Our Case Number: ACP-324383-26

Re: Proposed IDA Belview Infrastructure Development
Belview, Slieverue, County Kilkenny

Planning Ref: 177AE IDA Belview Infrastructure Development Co. Kilkenny -

Re: Notification under Section 177(AE) of the Planning Development Act 2000 (as amended)

Figure 3.1 Habitat map of the indicative site area surveyed

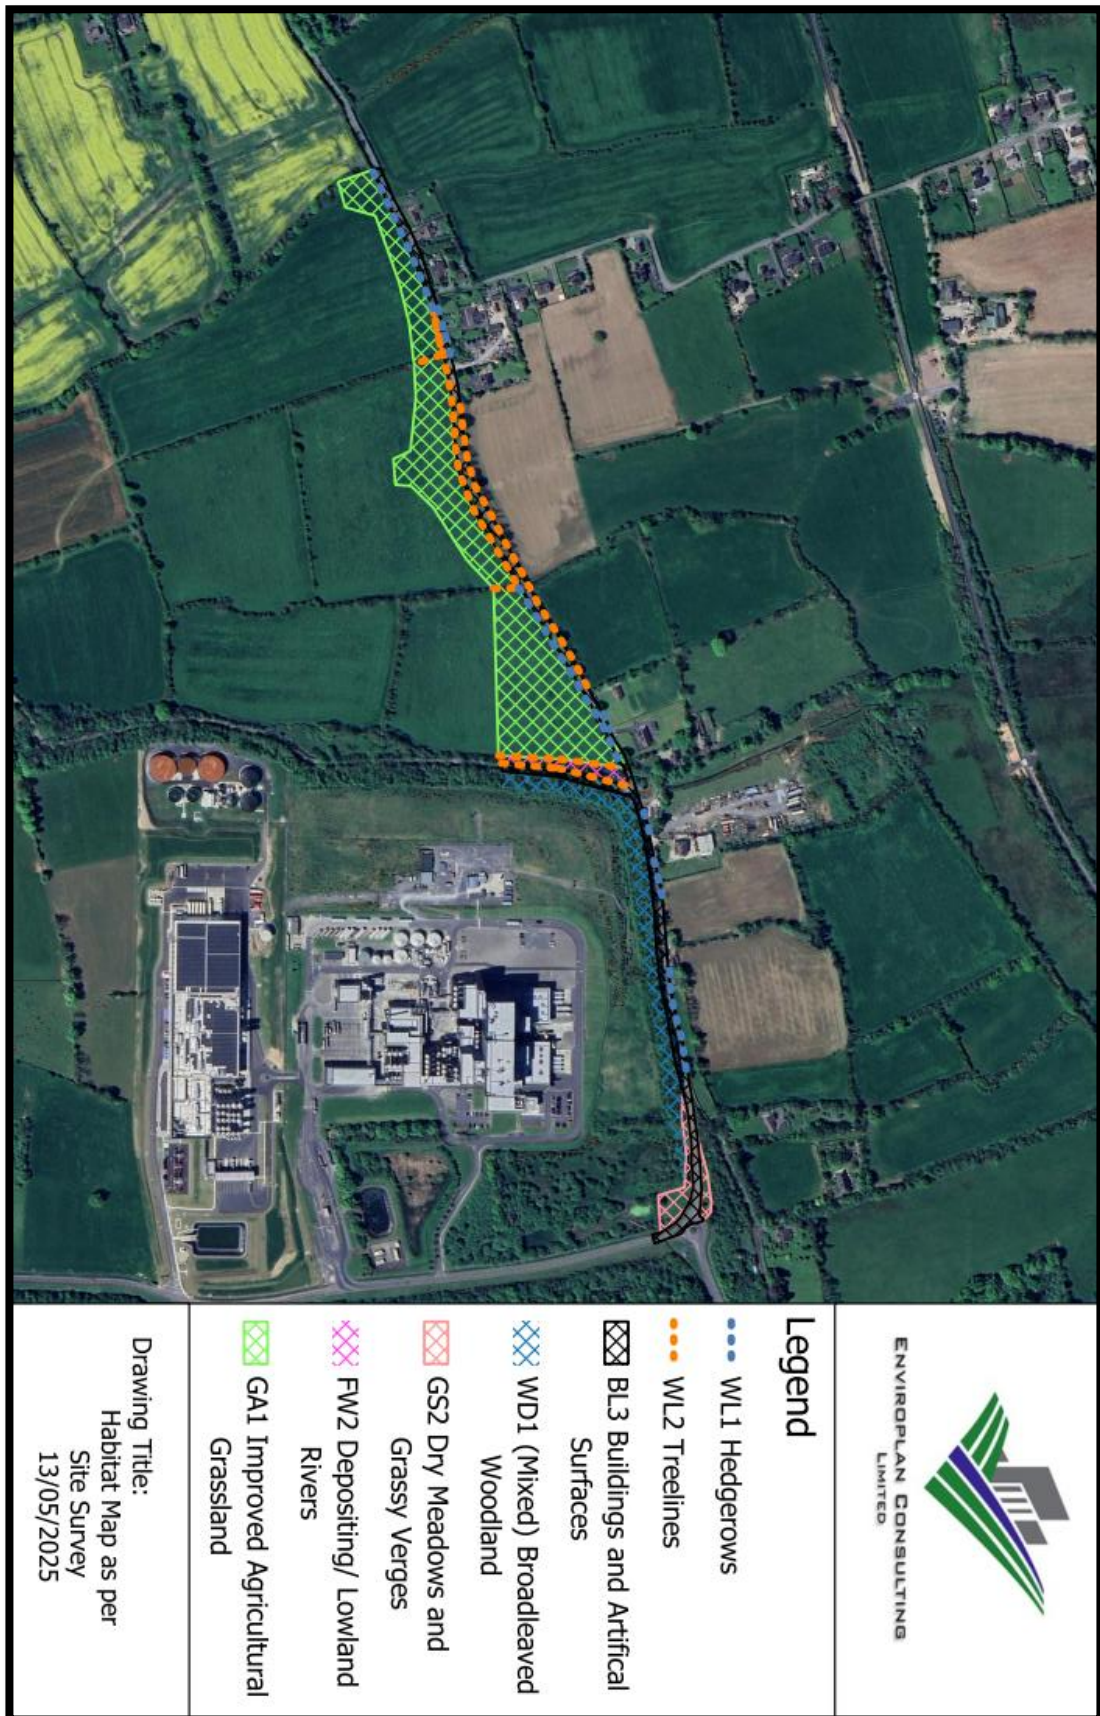
In particular, the assessment of otter appears deficient. Otter is a Qualifying Interest of the Lower River Suir Special Area of Conservation (SAC) (Site Code: 002137), and the NIS acknowledges that a stream traverses the site and is hydrologically connected to the SAC. However, no dedicated otter survey appears to have been undertaken and the assessment relies primarily on a one-week wildlife camera deployment which did not record the species. The absence of otter records during a short-duration camera survey cannot be relied upon to demonstrate absence from a watercourse corridor. No evidence has been provided of a systematic otter survey assessing the stream corridor for spraints, tracks, couches, holts, resting sites or commuting routes.

The proposed development includes culvert works and road infrastructure adjacent to a watercourse corridor. However, there is limited assessment of potential impacts on otter movement, habitat connectivity, or use of the stream corridor during either the construction or operational phases.

Furthermore, only one static detector location appears to have been deployed at the site, notwithstanding the linear nature of the development and the presence of multiple habitat features including a stream corridor, treelines and hedgerows. It is therefore unclear whether the spatial extent and seasonal pattern of bat activity have been adequately characterised.

Any otter survey should be undertaken in accordance with recognised best-practice guidance and should include a systematic survey of suitable habitat both upstream and downstream of the proposed works area. The survey should assess the presence of spraints, prints, feeding remains, couches, holts, lying-up areas, access points, crossing points and commuting routes, as well as the suitability of existing and proposed culvert structures for otter passage. At a minimum, the survey should be undertaken in accordance with TII/NRA *Guidelines for the Treatment of Otters Prior to the Construction of National Road Schemes* and should be completed prior to determination of the Part 8 proposal in order to adequately establish the ecological baseline and inform the assessment of potential effects.

PROJECT NAME: PLD IDA Bellview Site, Kilkenny	
PROJECT No: R2	
SCALE: 1:3500	DATE: 16 April 2026
CALCULATION: Horizontal Illuminance (lux)	
DESIGNER: D.Larkin (CMS)	
PREPARED BY:

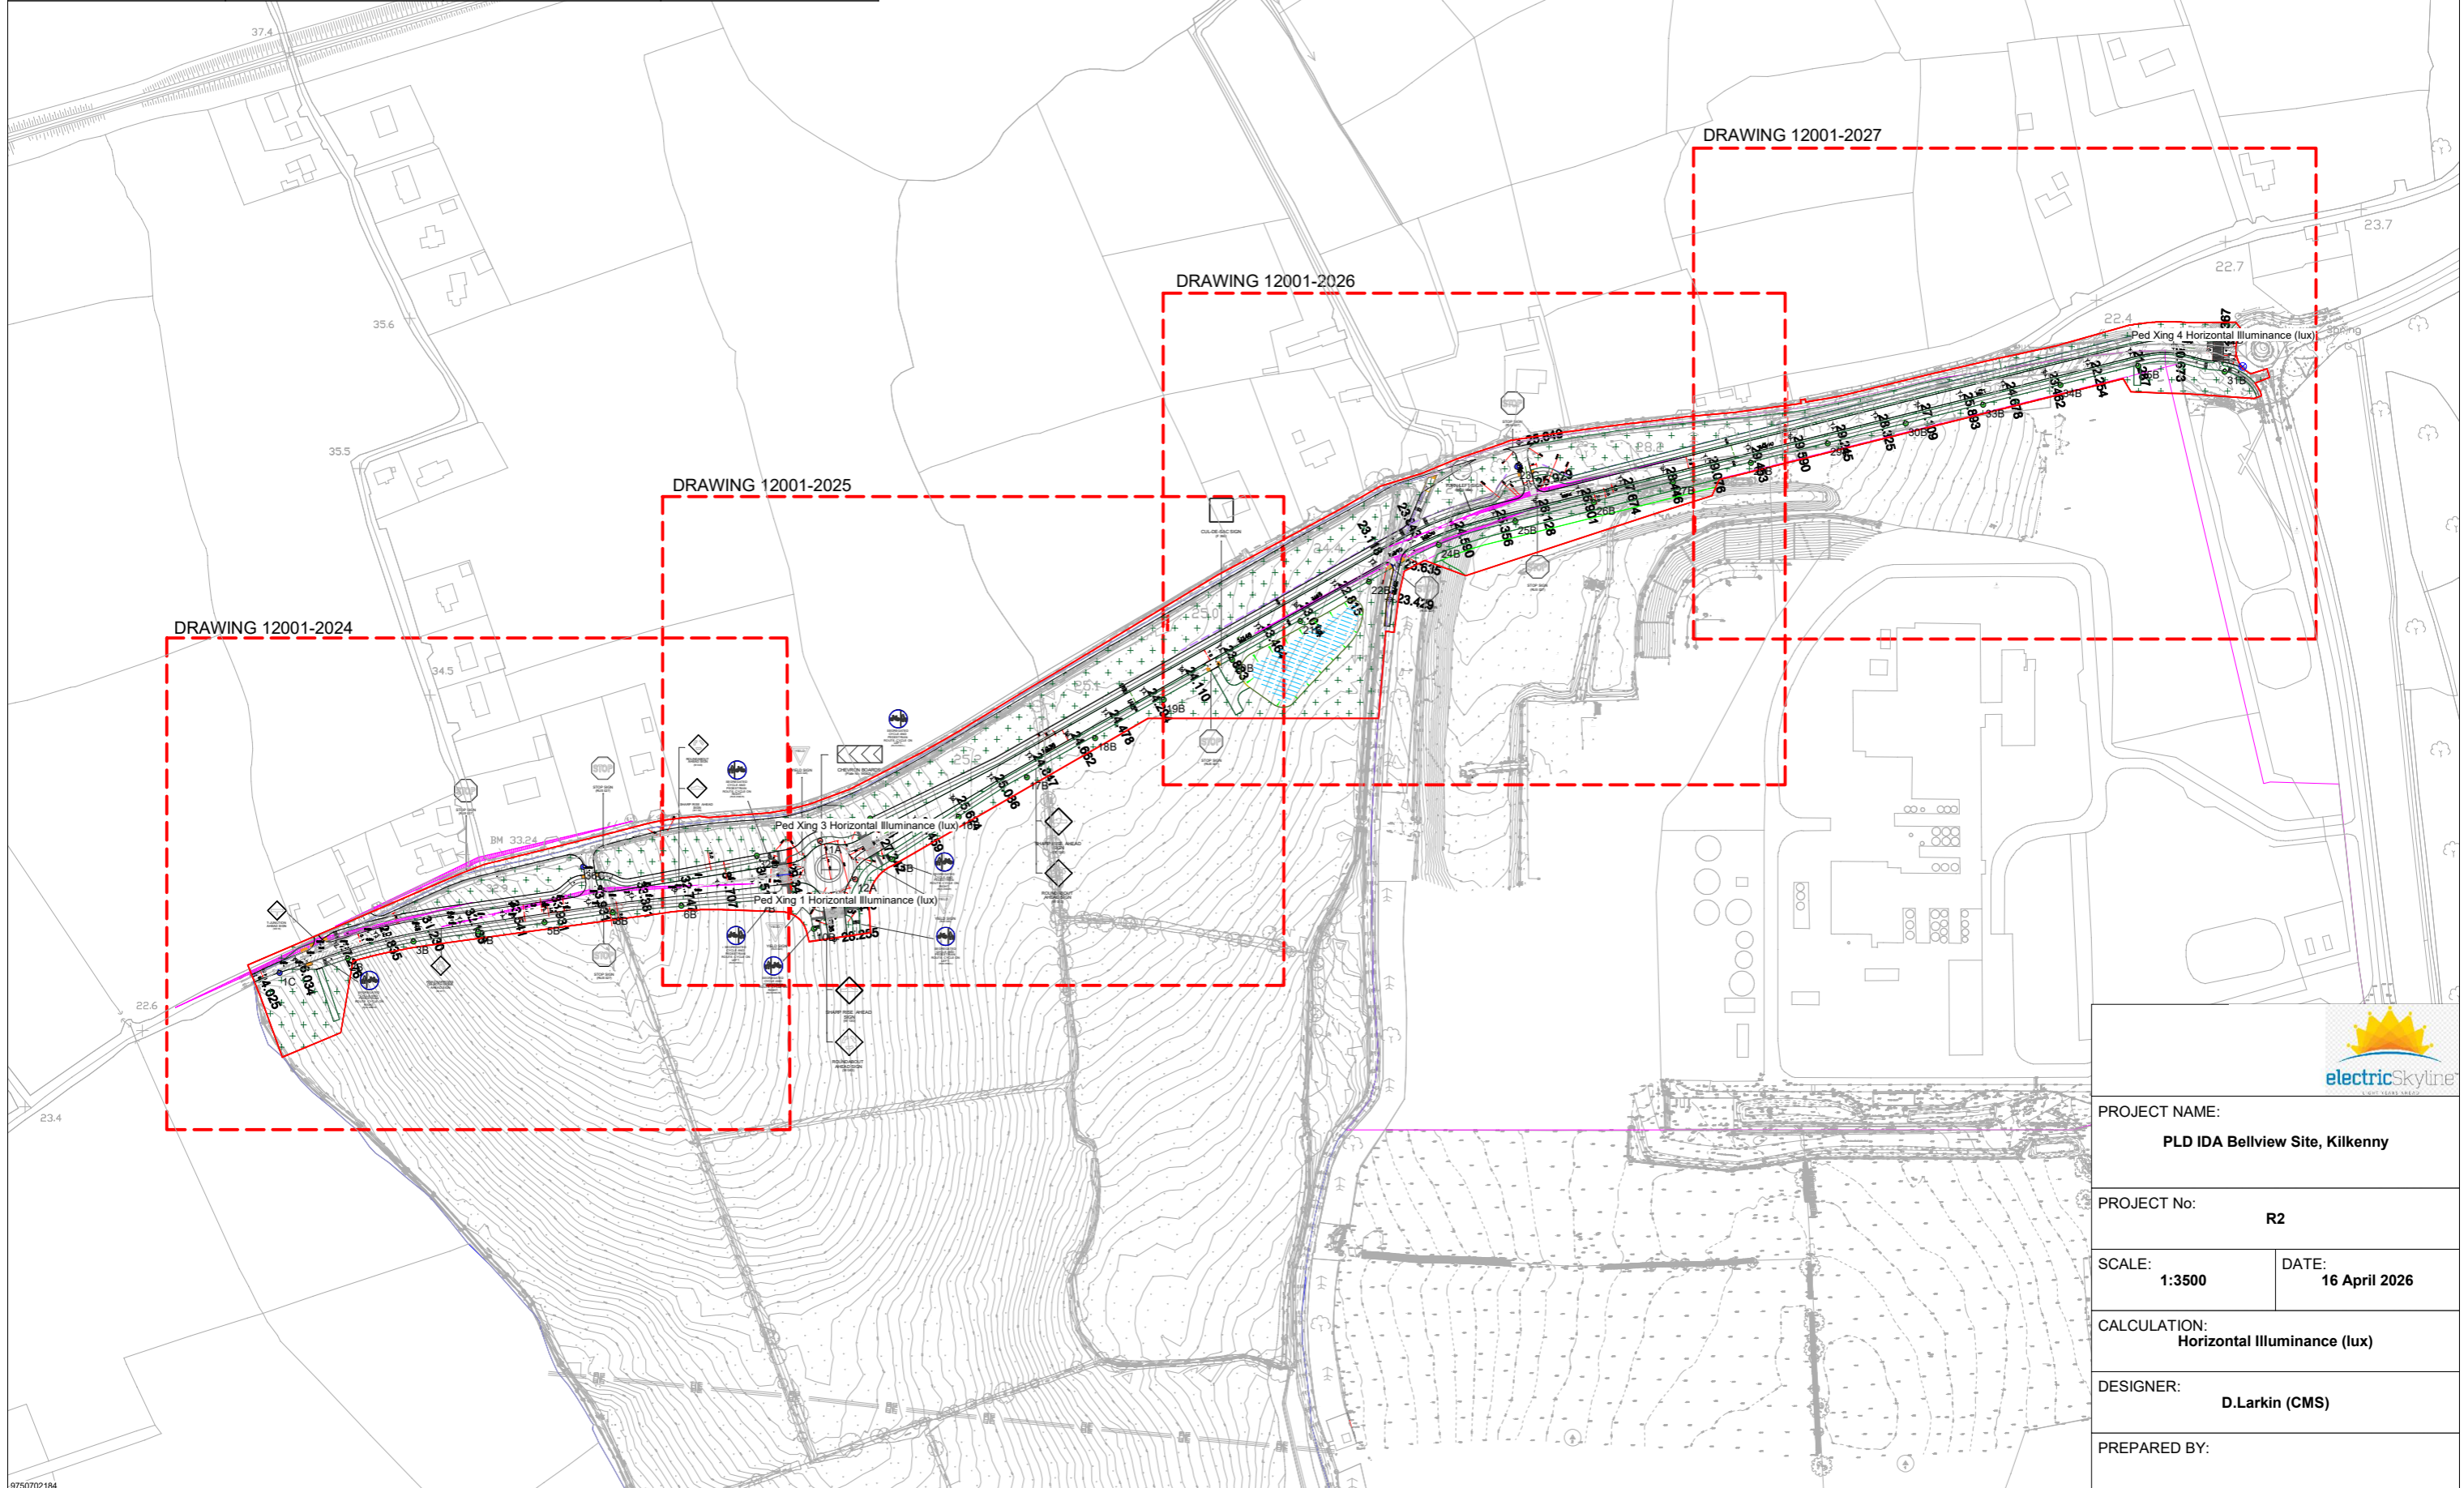
The proposed development includes public lighting as part of the road scheme. However, the EclA does not appear to contain a detailed assessment of operational lighting impacts on bats, including potential impacts on commuting routes, foraging habitat or light-sensitive species such as Brown Long-eared Bat.

Given that the proposed development includes public lighting, a bat-sensitive lighting assessment should be prepared in accordance with current bat conservation guidance and should demonstrate how important commuting and foraging features will be protected from artificial light spill.
